From: Chris Moore <[REDACTED]>
Sent: 30 June 2020 12:34
To: Sian Eggington
Subject: RE: Request for further information P/55/20/HH
Categories: Green Category

Thank you for the letter – in reply to your comments;-

Subject: Request for further information P/55/20/PL

GROUND FLOOR PLAN

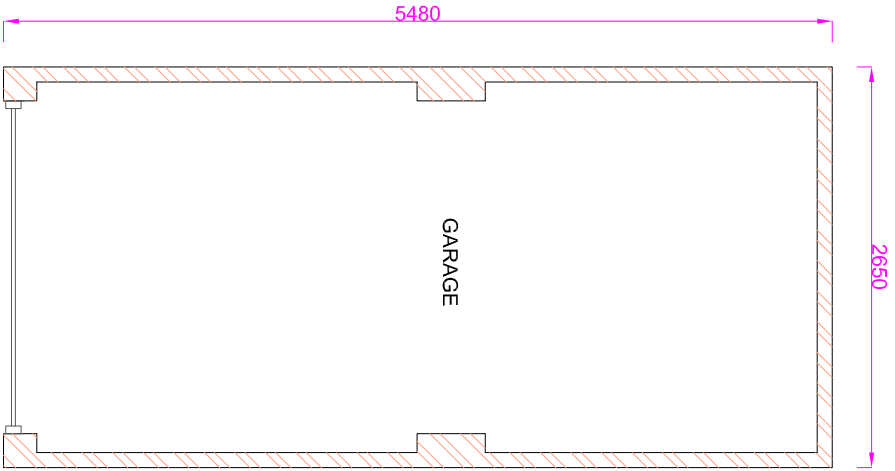
Room Labels: You are required to have room labels on all floor plans. Please amend. – Amended.

Site Plan (scale 1:500)

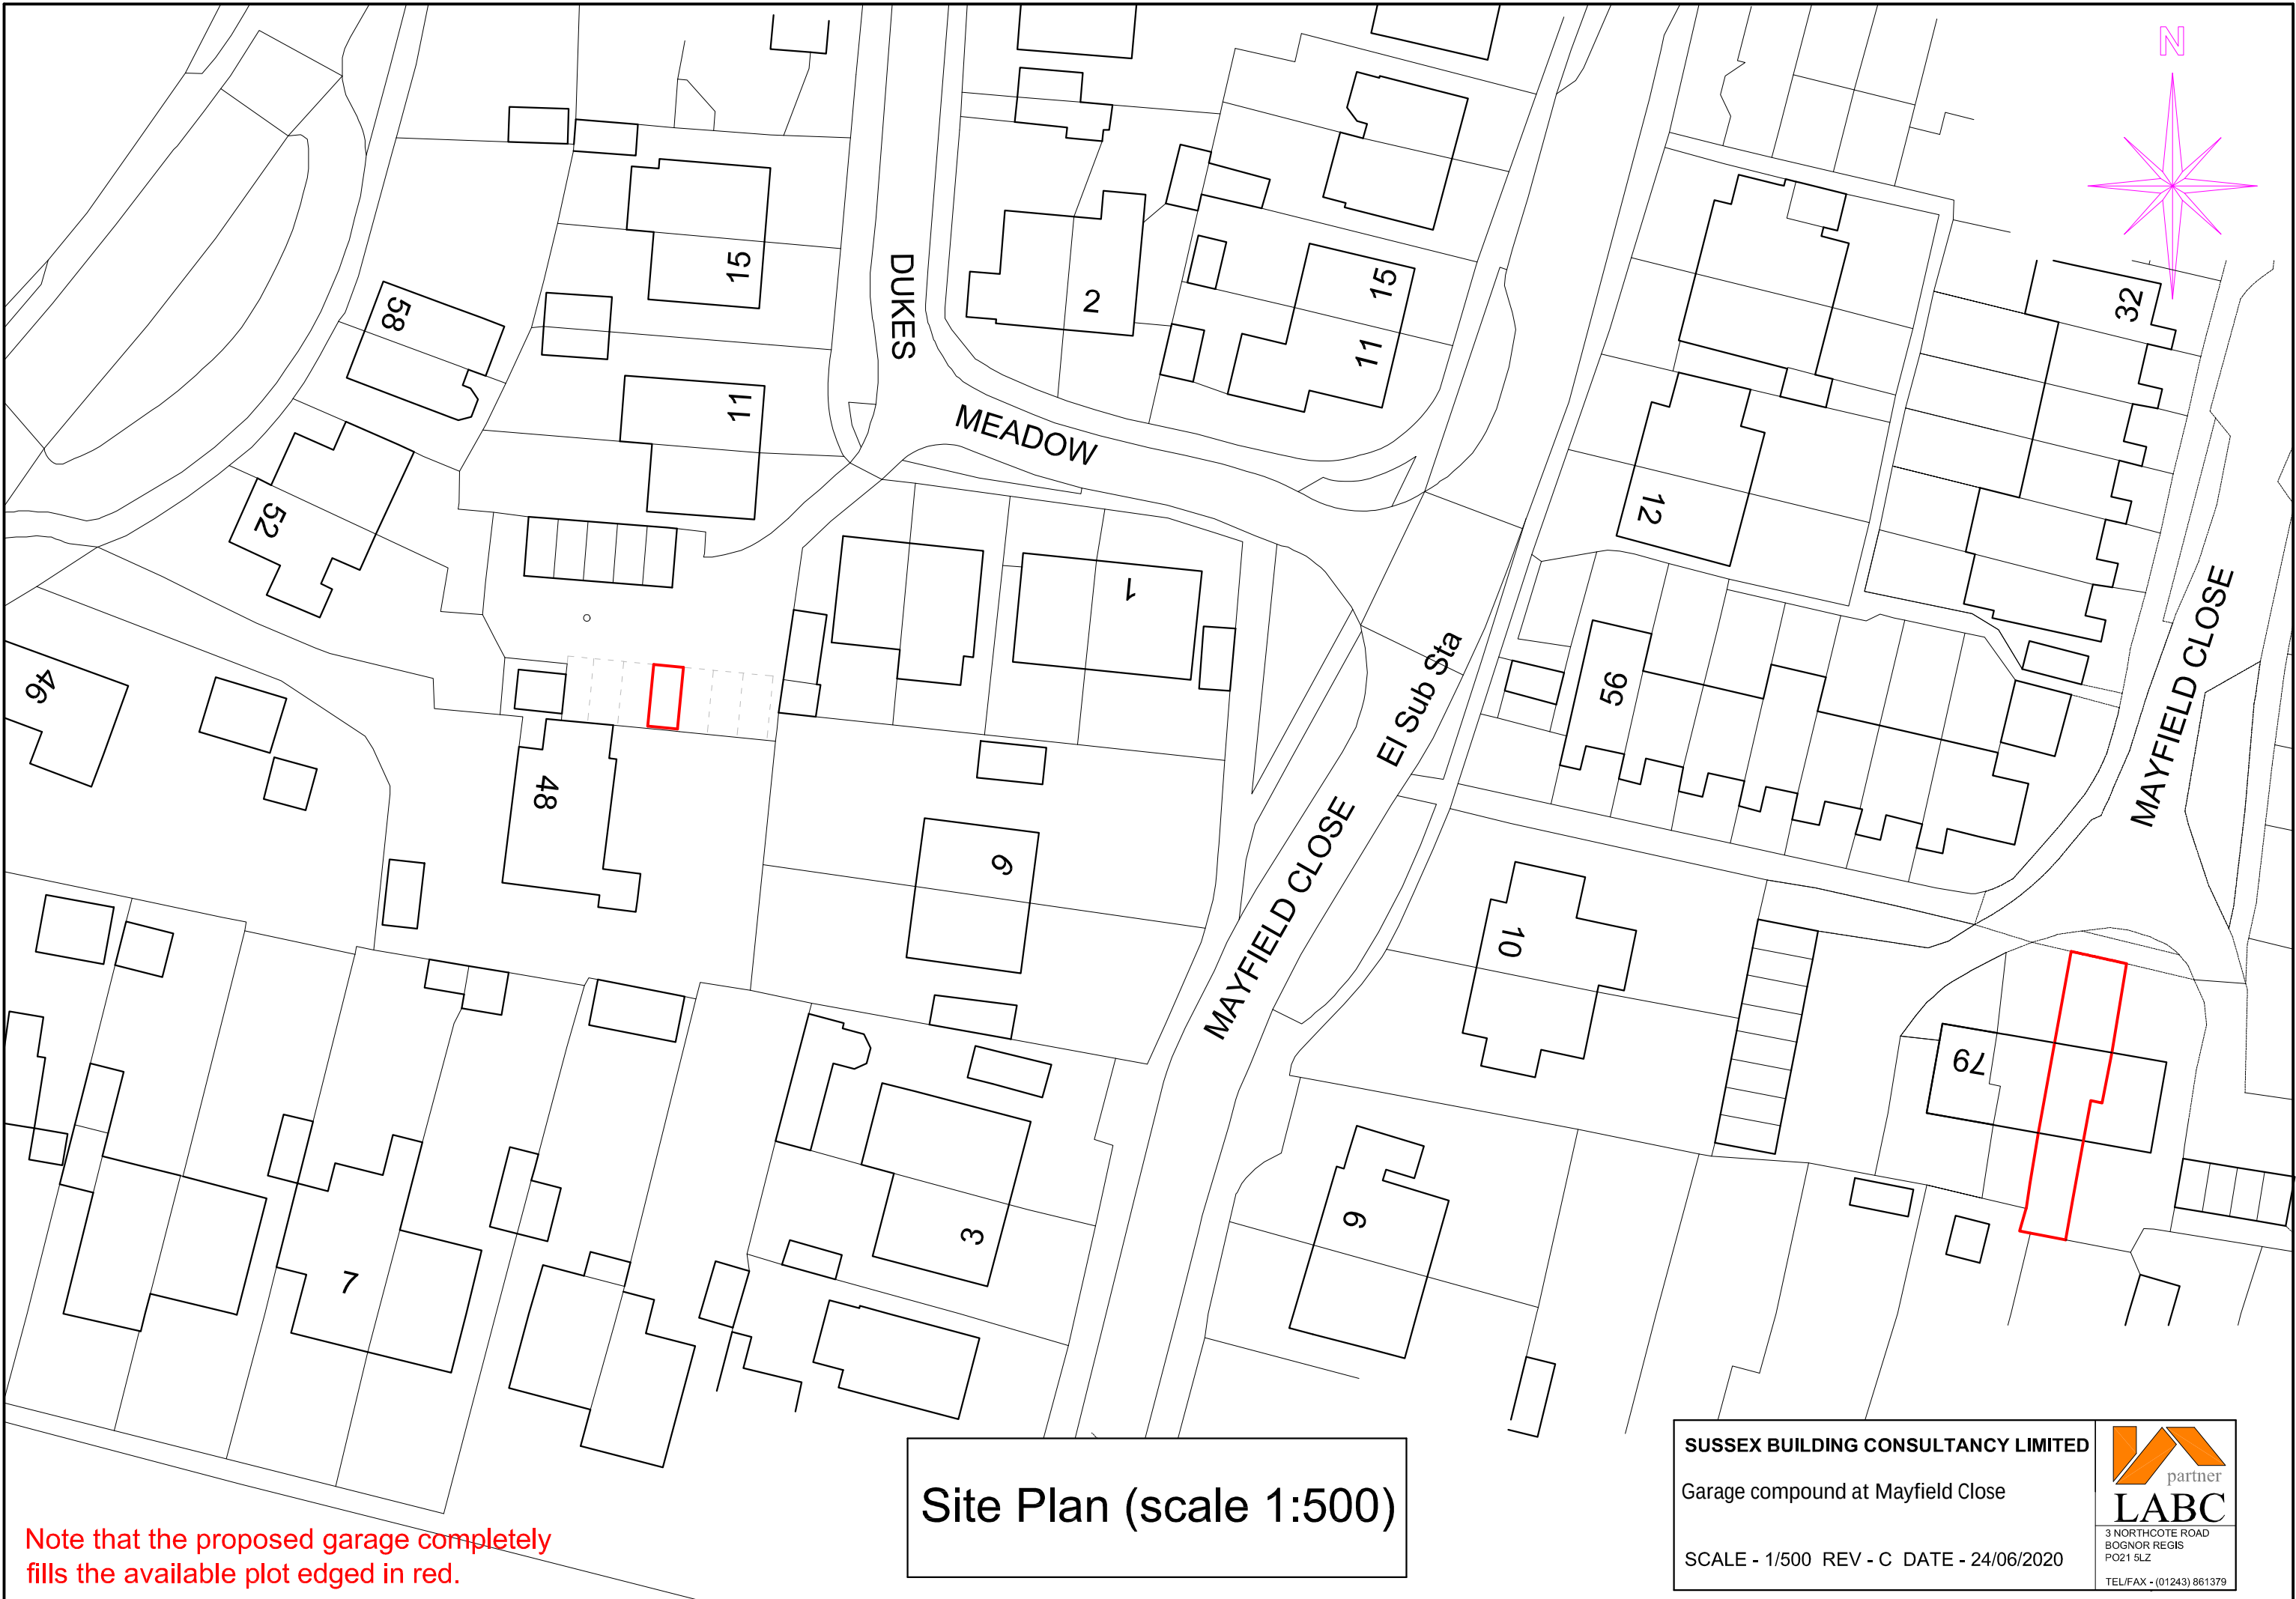
Block Plan: Please submit a proposed block plan with dimensions to all site boundaries. – The new garage completely fills the available plot size so no distance to boundaries – I have put a note in RED on the site plan.
